Consultation Response from KC, Highways Development Management		
2021/90749 Land adj, 105, Highgate Lane, Lepton, Huddersfield, HD8 0HQ		
Demolition of detached garage and conservatory and erection of two detached dwellings and associated landscaping		
Date Responded: 11/05/2021	Responding Officer: Zack Turner	Responding Ref: K11-18SW/2

2021/90749

Highways Development Management (HDM) comments as follows.

PLOT 2 (PLOT 1 SAME BUT HANDED)
FLOOR PLANS & ELEVATIONS

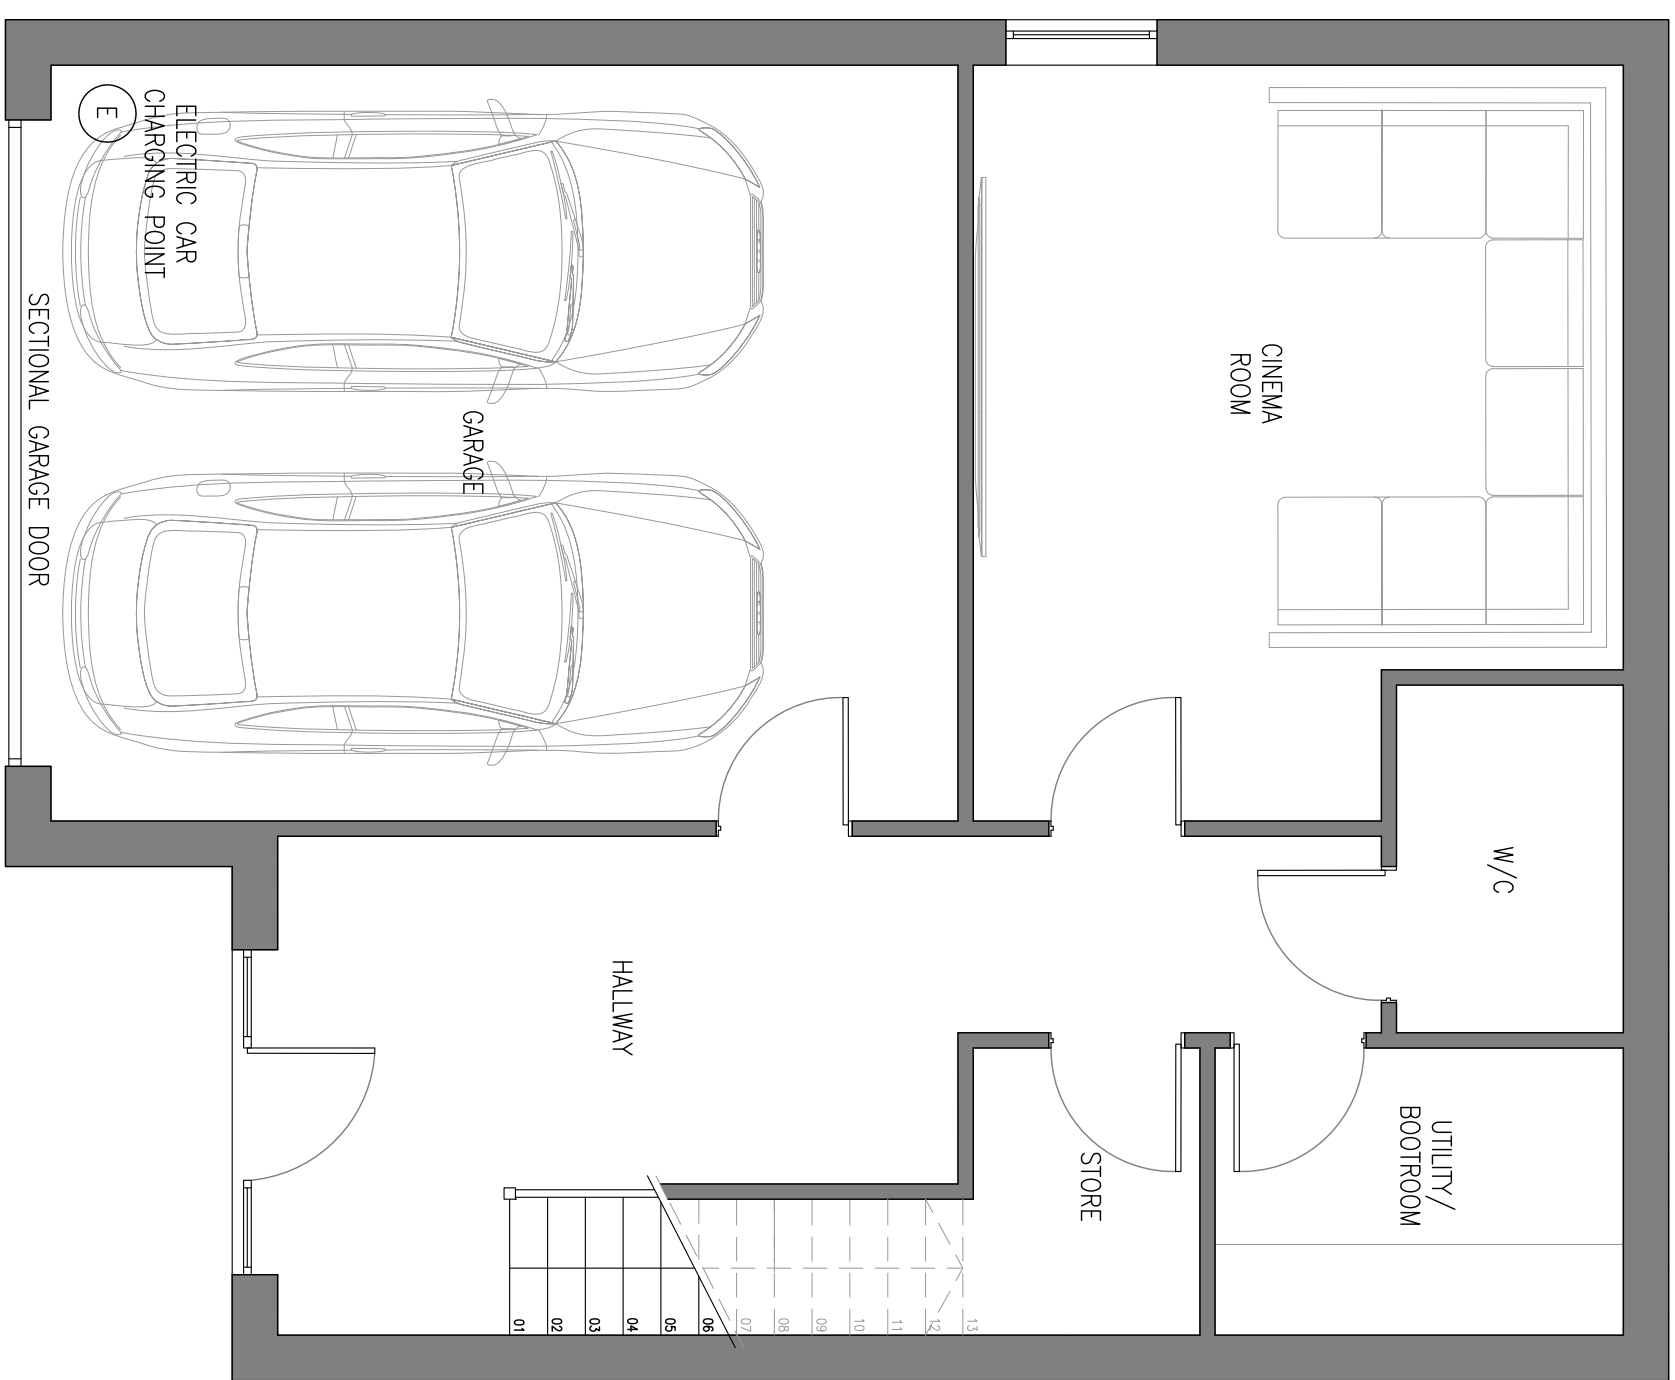
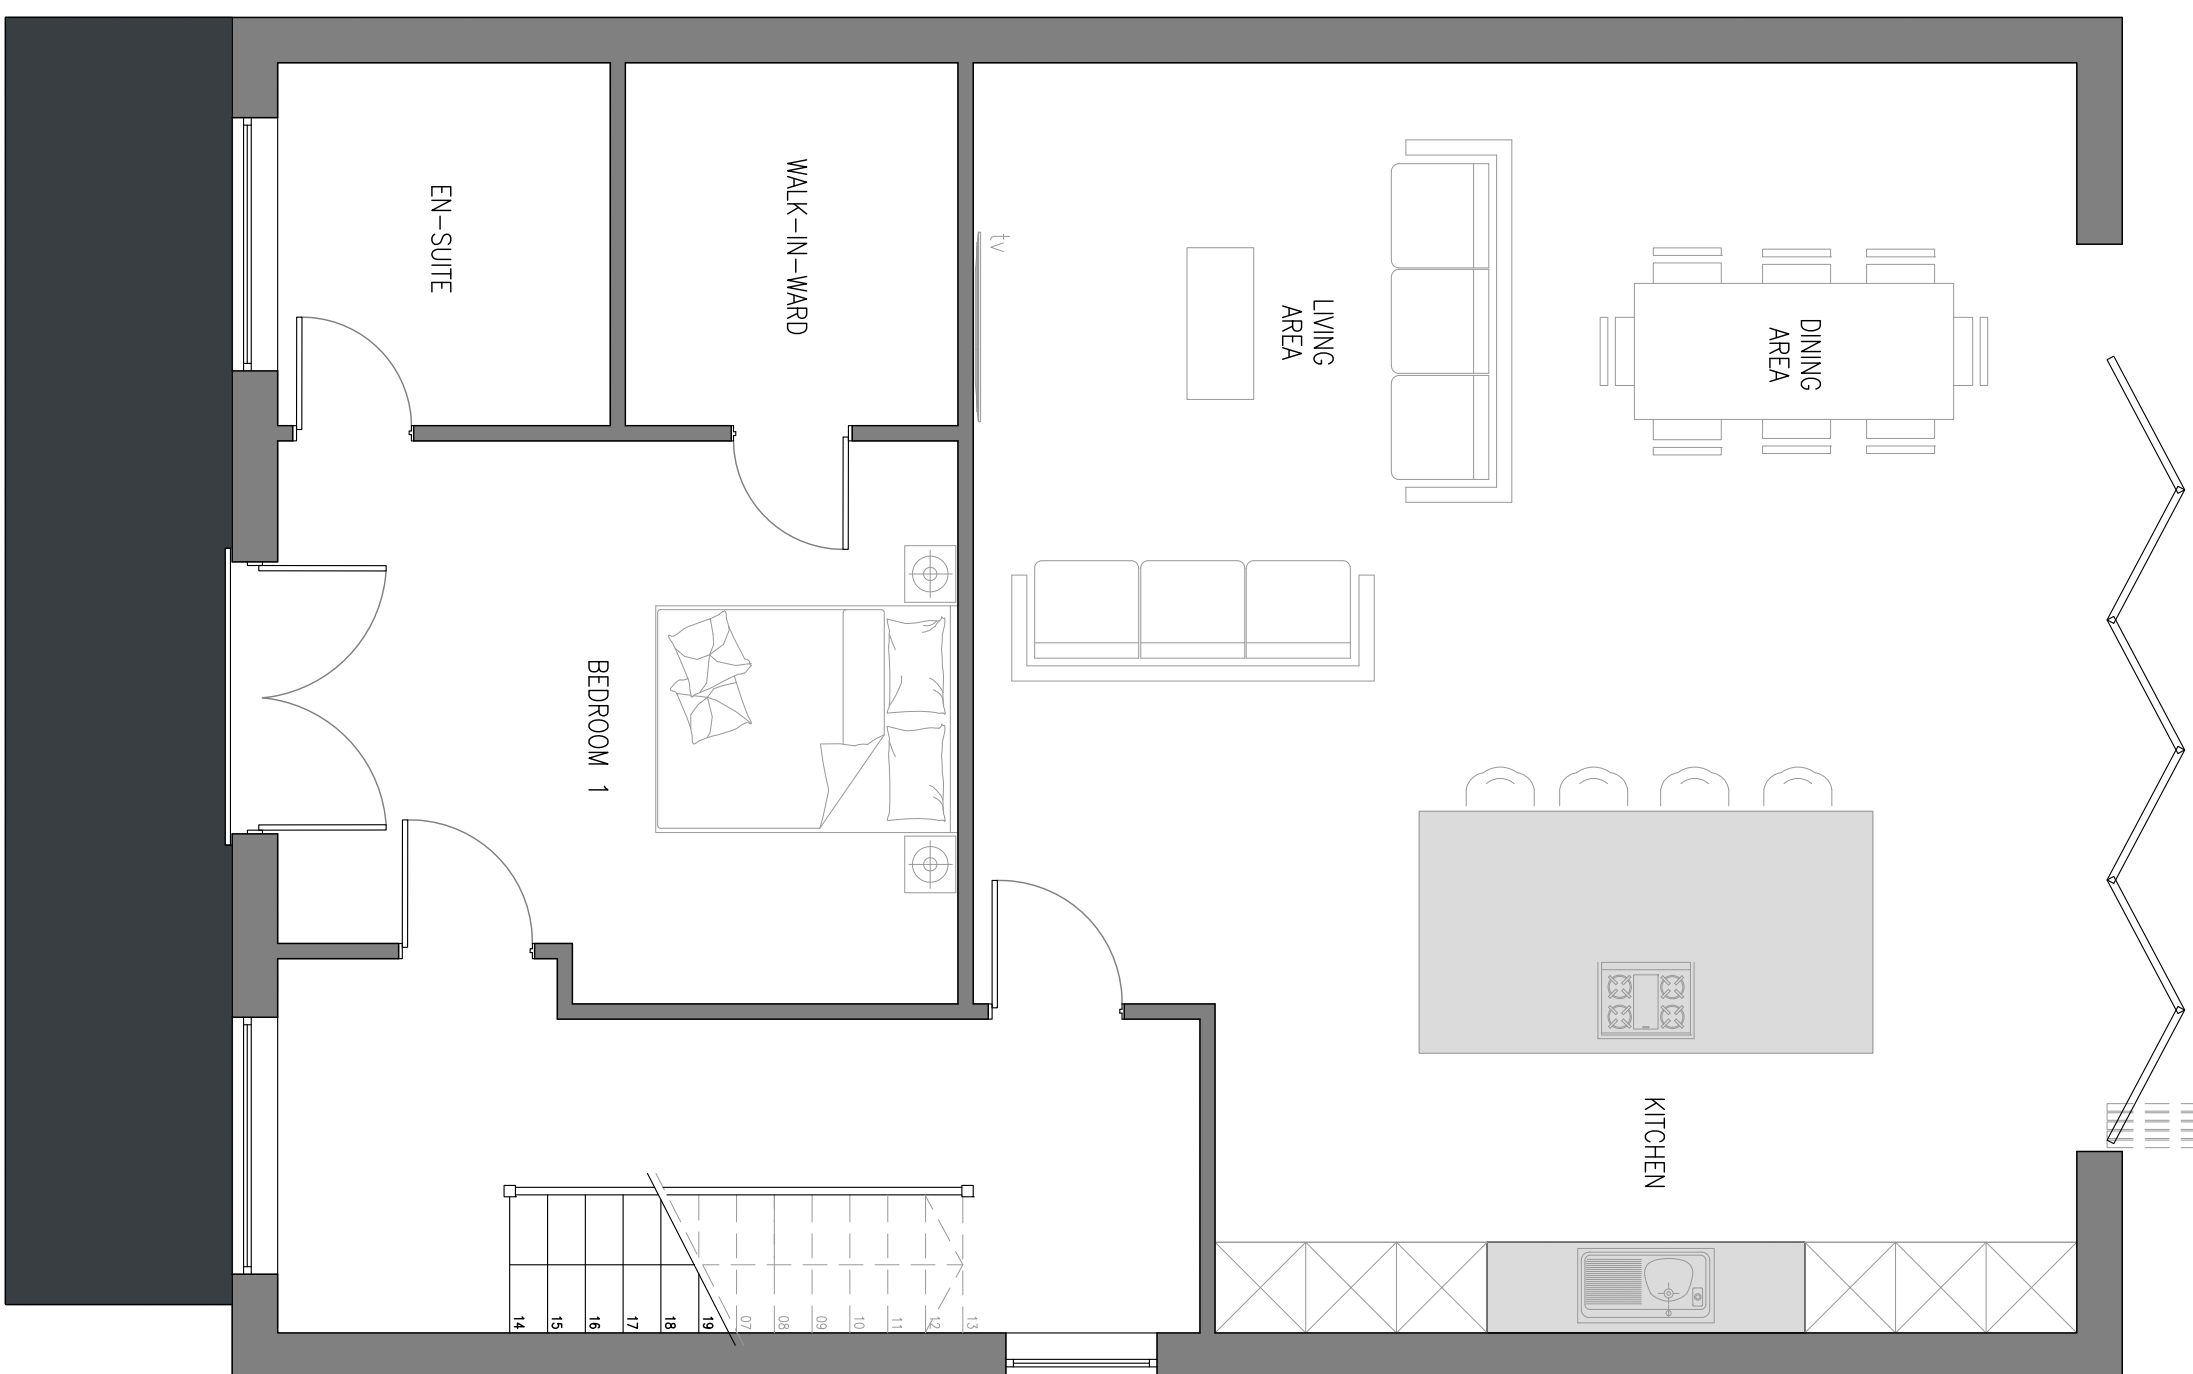
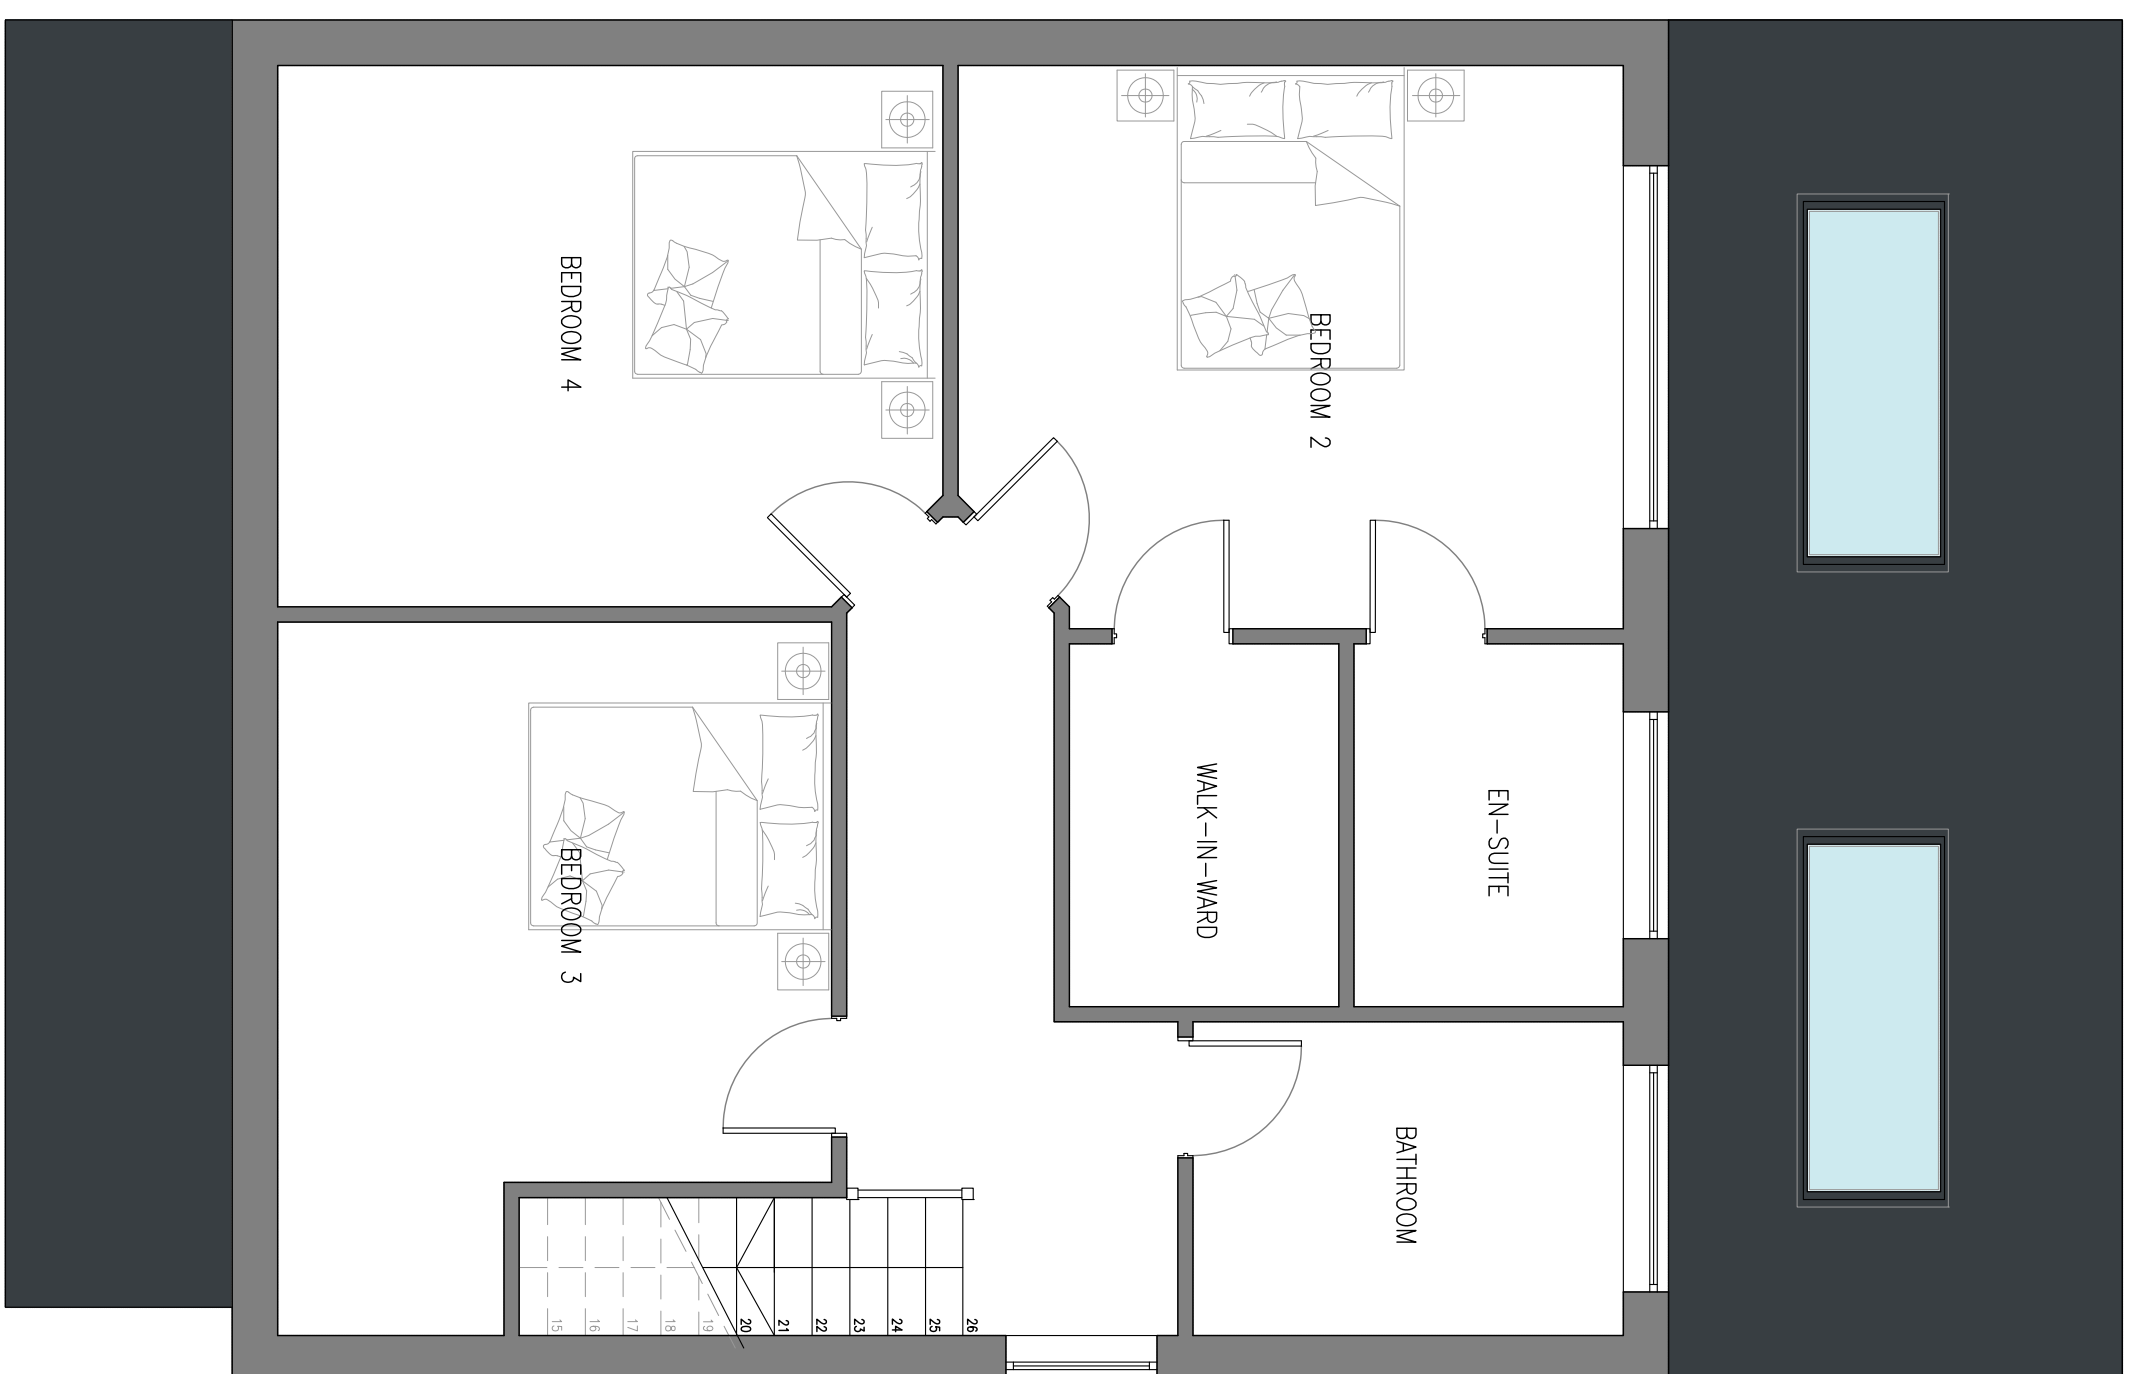
The 2 new dwellings will both have 4 bedrooms and sufficient parking is being provided by an integral double garage with space in front for an additional 2 parking spaces for each dwelling.
